WEST SUSSEX COUNTY COUNCIL CONSULTATION

TO:	Arun District Council FAO: Mr S Davis
FROM:	Highways, WSCC
DATE:	12/06/2018
LOCATION:	Land west of Fontwell Avenue, 1 Fontwell Avenue, Eastergate PO20 3RU
SUBJECT:	AL/136/17/PL Erection of pair of semi-detached houses & new access onto A29 - This is a Departure from the Development Plan
DATE OF SITE VISIT:	n/a
RECOMMENDATION:	☒ Advice ☐ Objection ☐ Modification ☐ No Objection ☒ More Information ☐ Refusal
S106 CONTRIBUTION TOTAL:	n/a

FIRM NAME ELLIS ASSOCIATES (BEXLEY) LTD 07939 129938	
CLIENT & LOCATION MS E PARKER LAND AT FONTWELL AVENUE EASTERGATE CHICHESTER PO20 3RU	
PROJECT 2'No FOUR BEDROOM SEMI-DETACHED DWELLINGS	
SCALE: 1:500 DATE: MAY 18	DRG NO: CHI/17089/P 3 OF 3

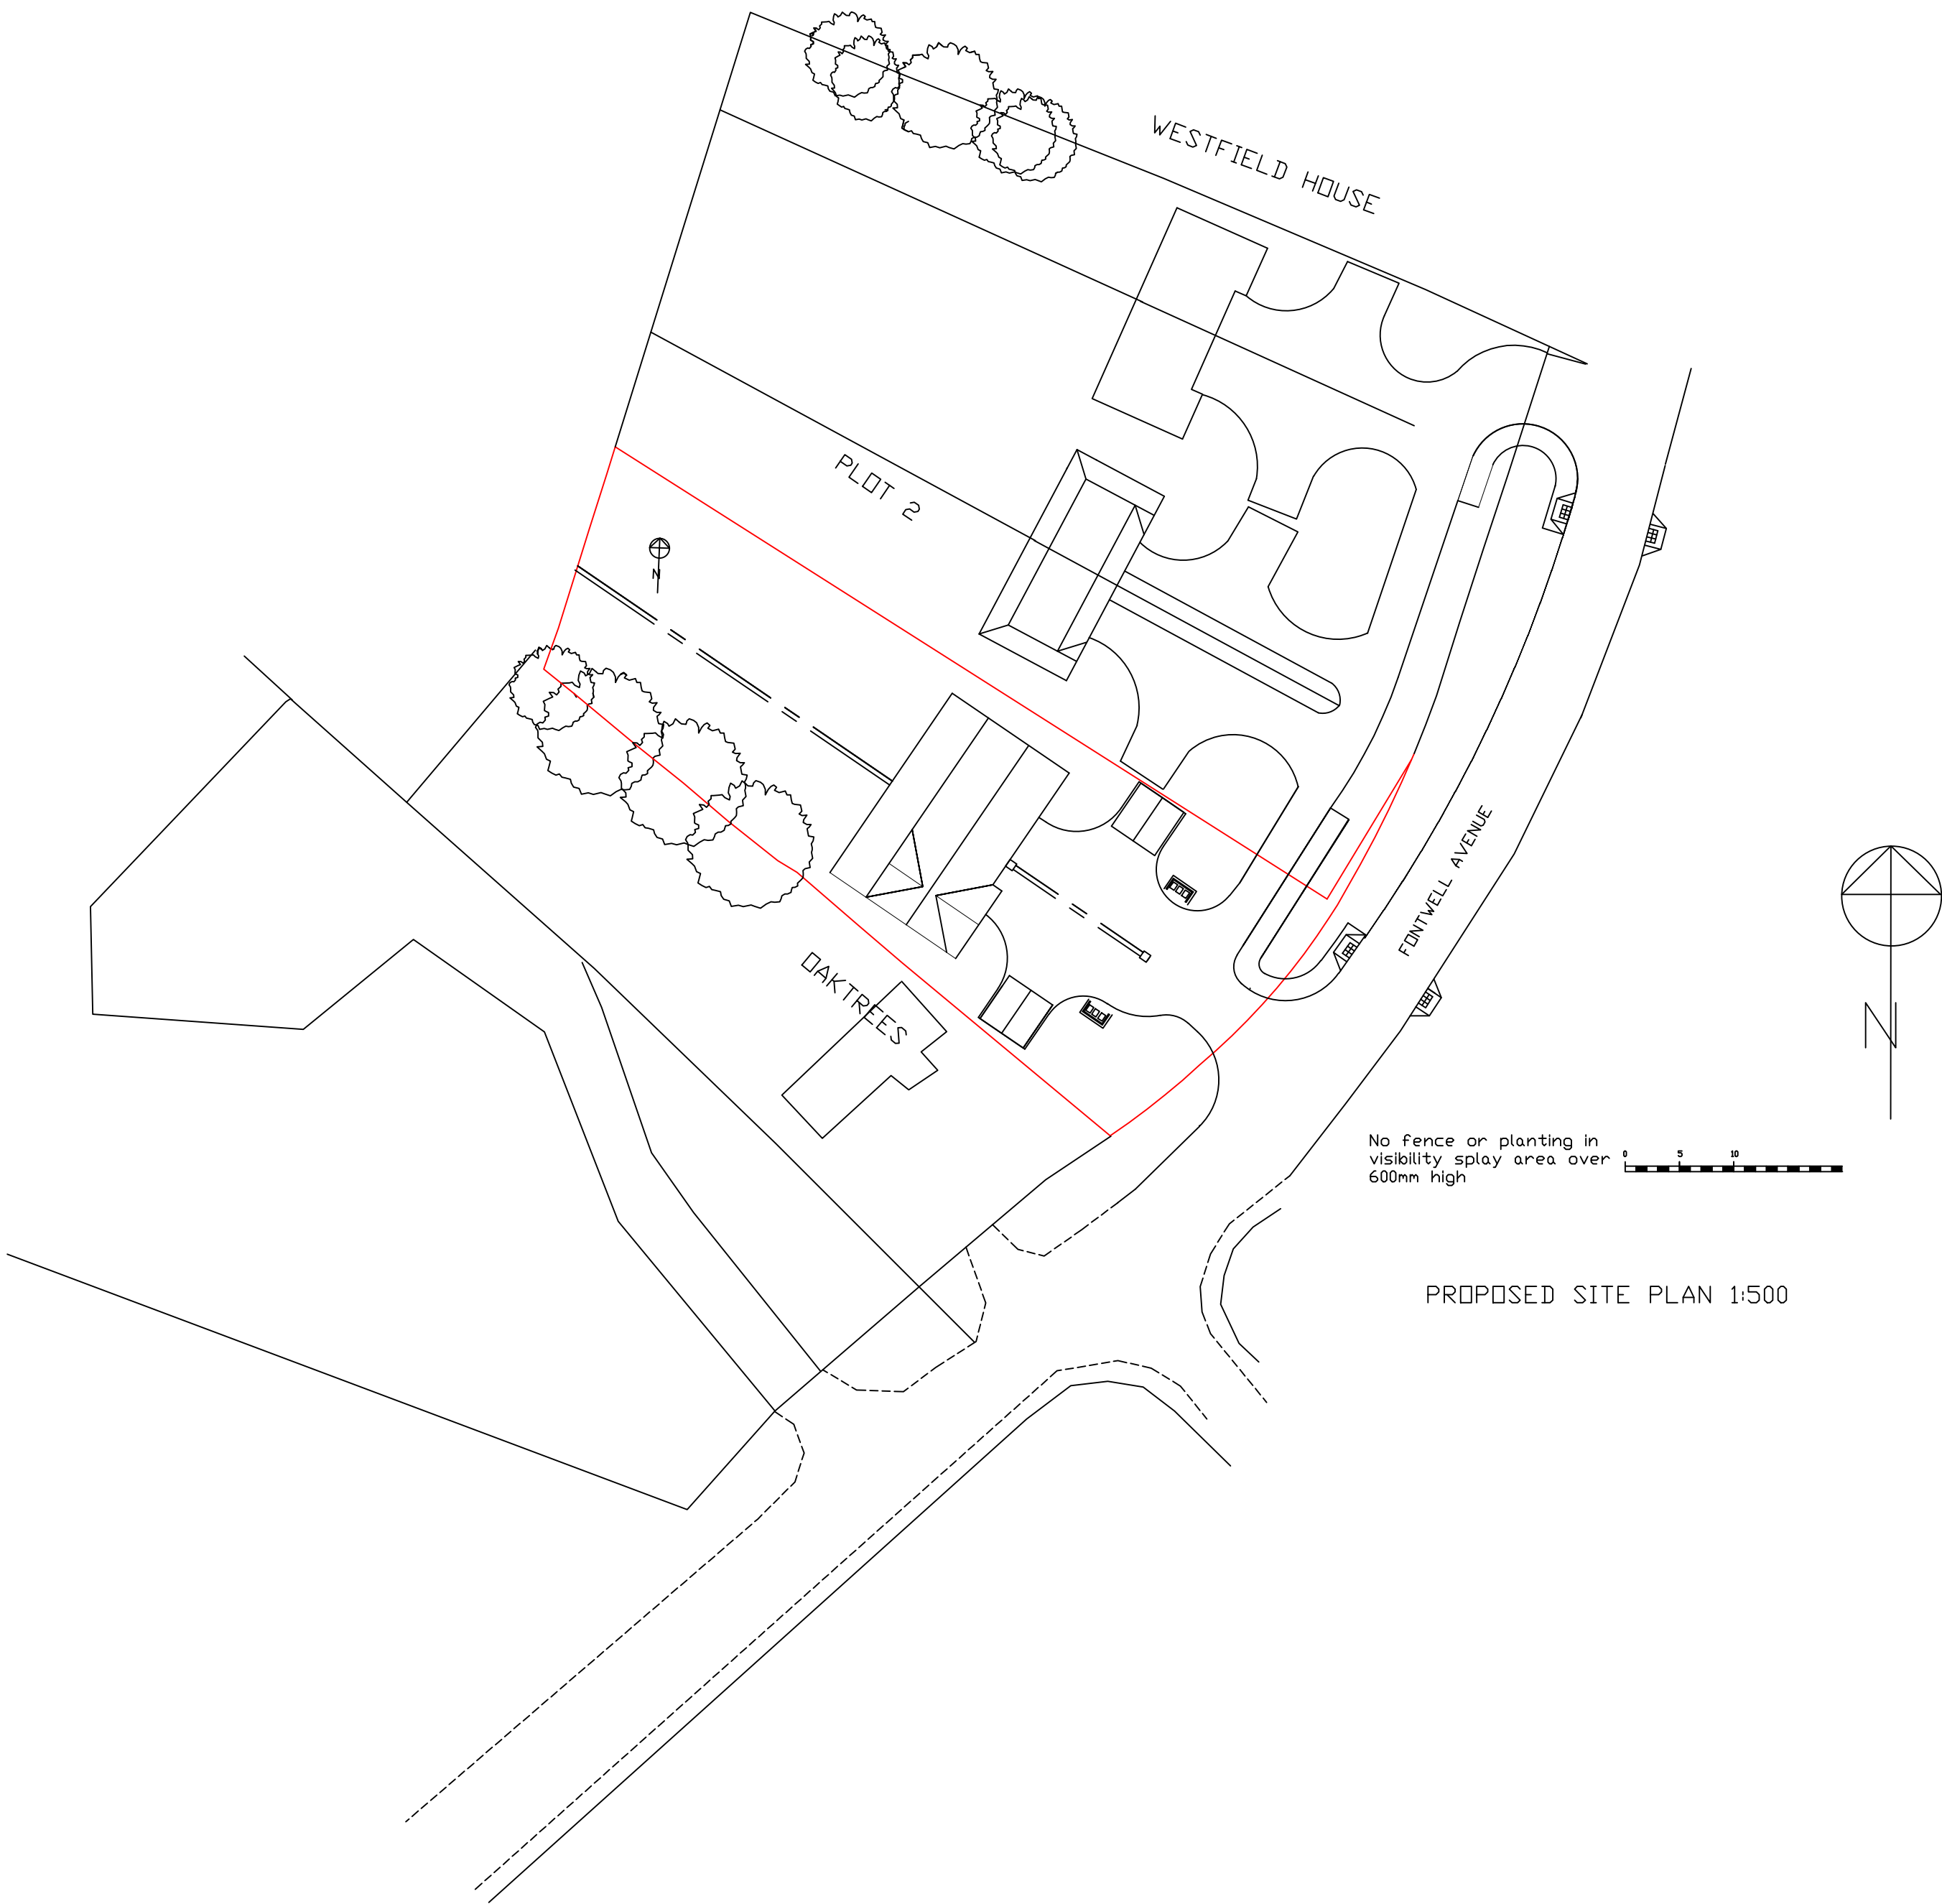
I note to the north a 2.4 x 63 metre visibility splay has been annotated on the proposed site plan. This is greater than the minimum 59 metres splay as calculated using Manual for Streets Stopping Sight Distance calculation coefficients based upon the historic speed survey data of (37.1 mph 85th percentile approach speed). This splay seems to have been drawn to the extent of the highway boundary. As previously discussed the splay can be drawn up to 1.0 metre into the carriageway.

Nevertheless the Local Highways Authority is satisfied from the plans provided that formation of an appropriate splay in this direction will require the use of 3rd party land not considered public highway. Namely a slither of land associated with plot 2.

Given the nature of this site, which seems to have been split into different plots, the applicant should provide some clarification/assurances the formation of this splay is achievable in perpetuity.

For the reasons above I would also request the splay is demonstrated correctly prior to determination.
